# V1\_Drainage Report - Preliminary comments.pdf Markup Summary

SHEET  
**EX**  
 1

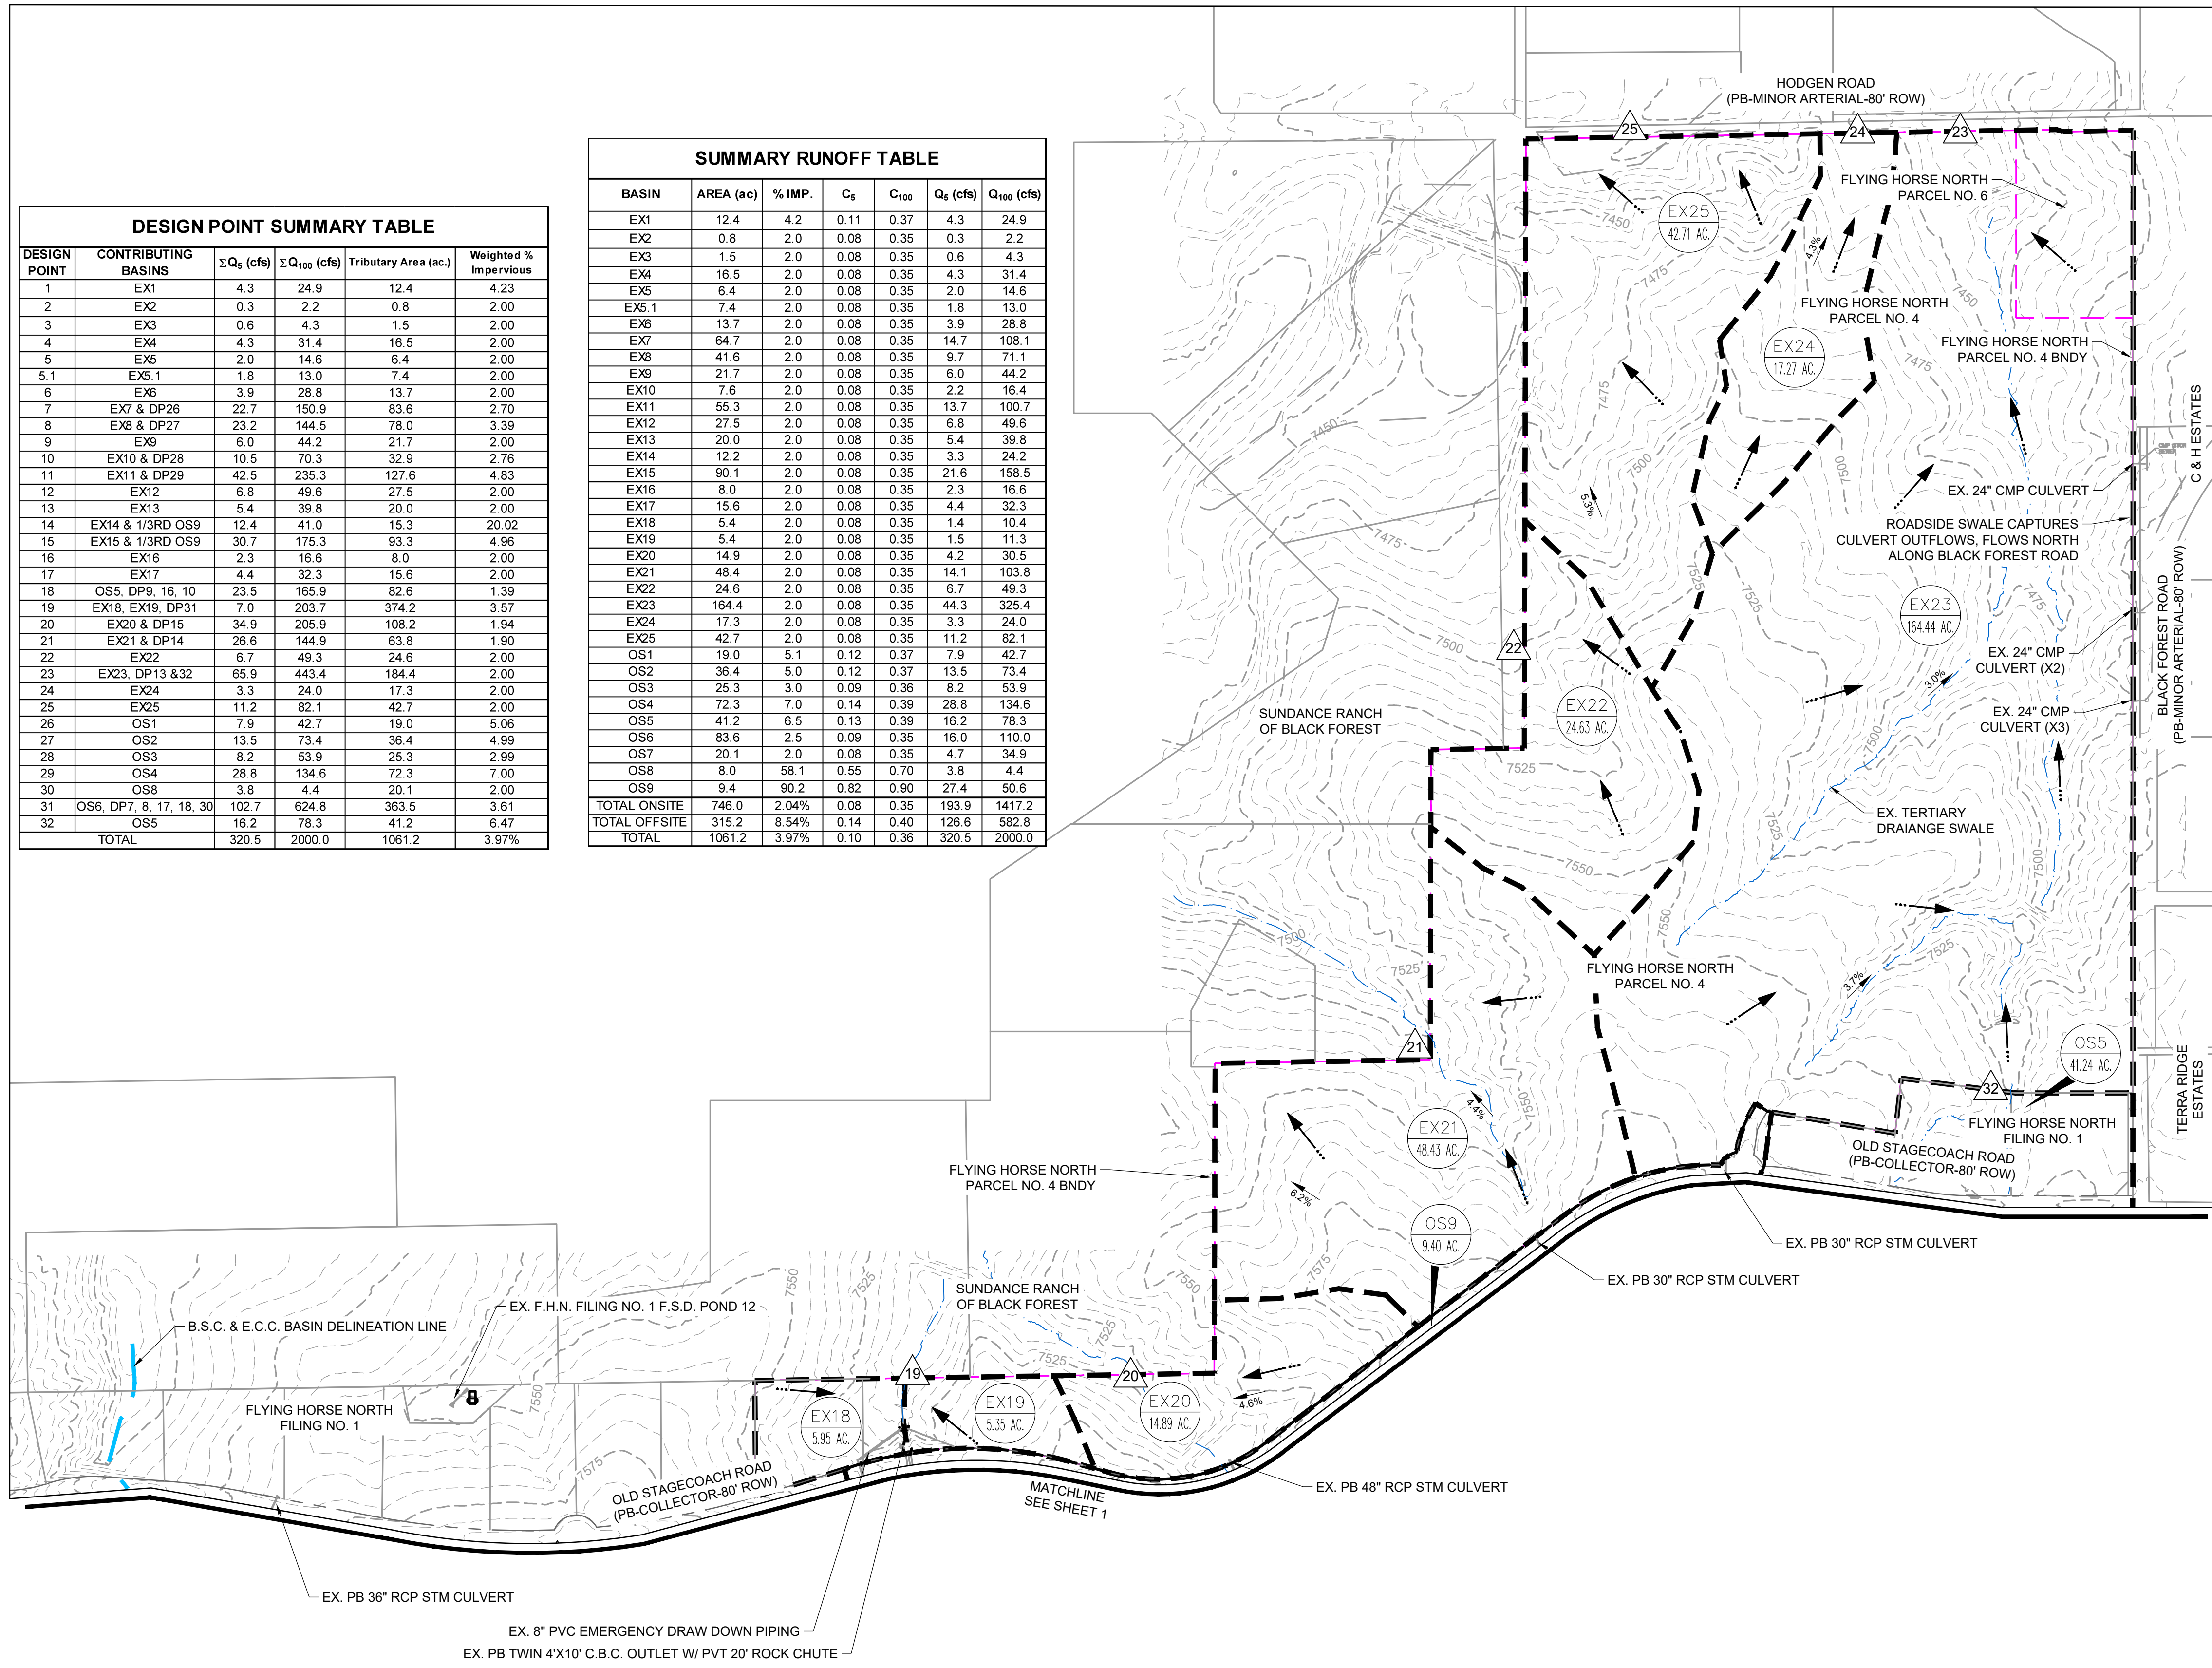
Please show and label all the existing culverts along Black Forest Road. Account for and show any off-site basins that impact the development. The narrative (page 4) indicates that flow is conveyed by these culverts from east to west into the site.

SHEET  
PR  
4

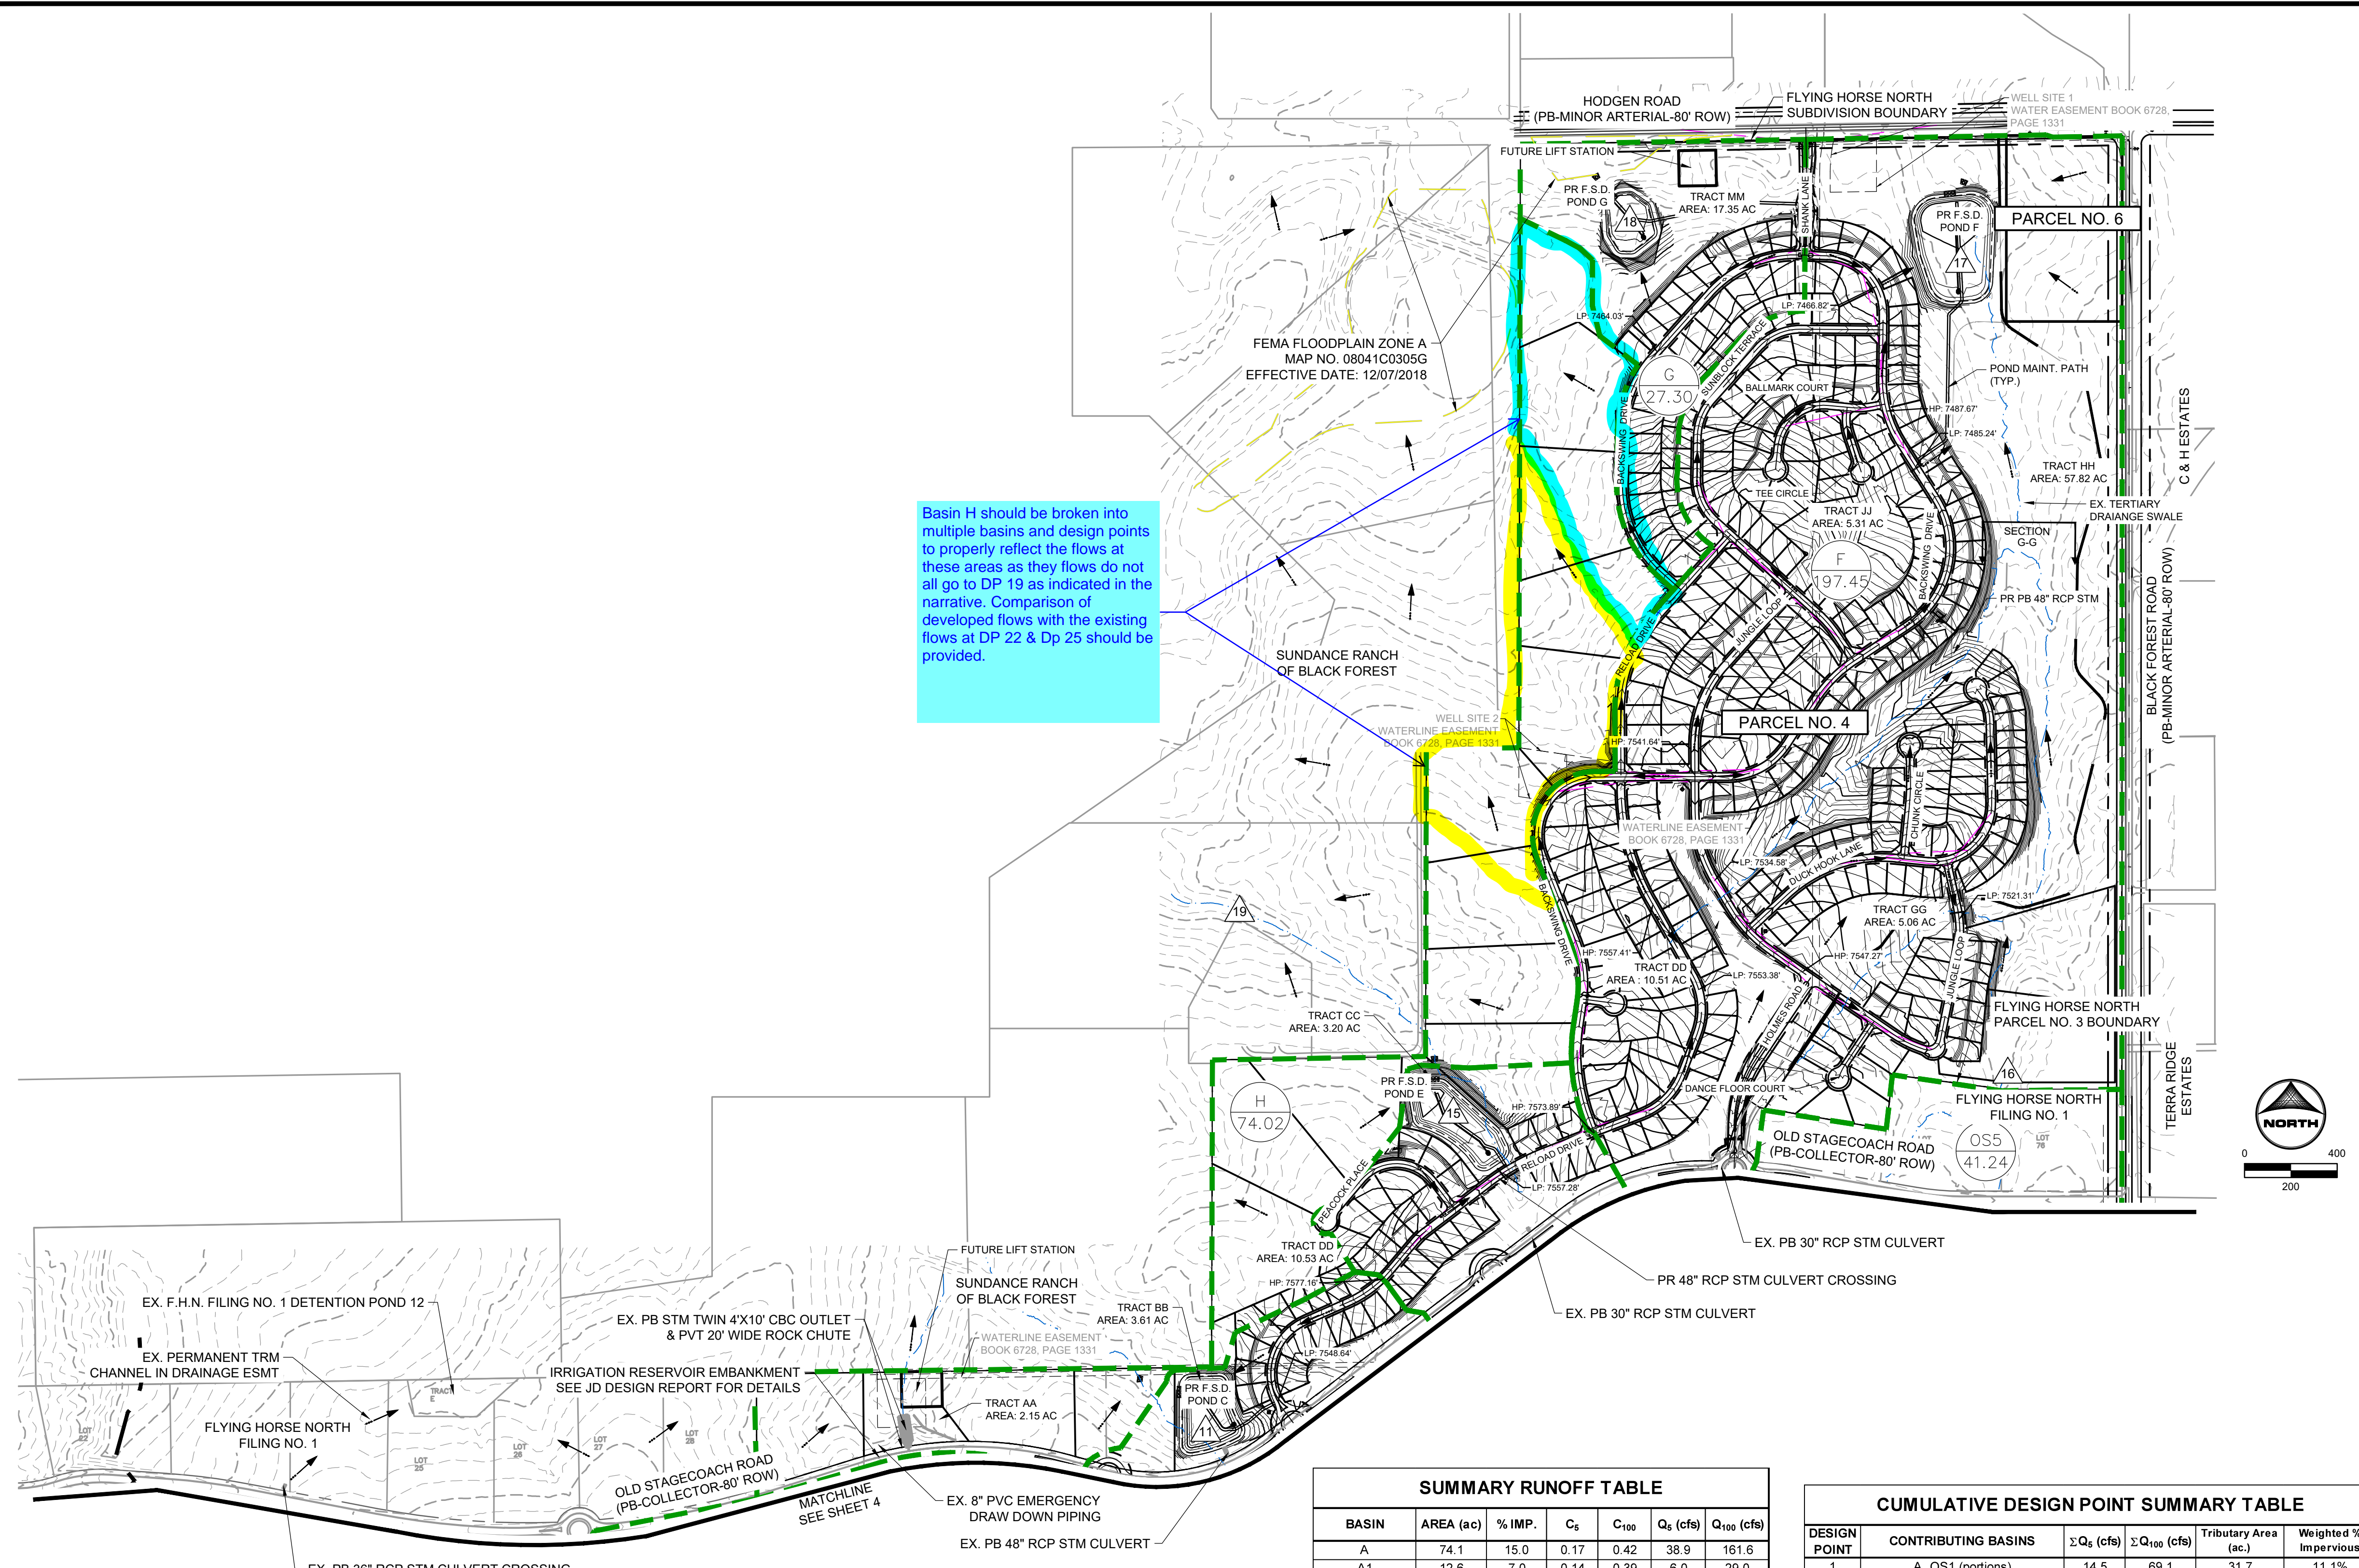
please label pond 12 on the drainage map.

label on the drainage plan

label pond
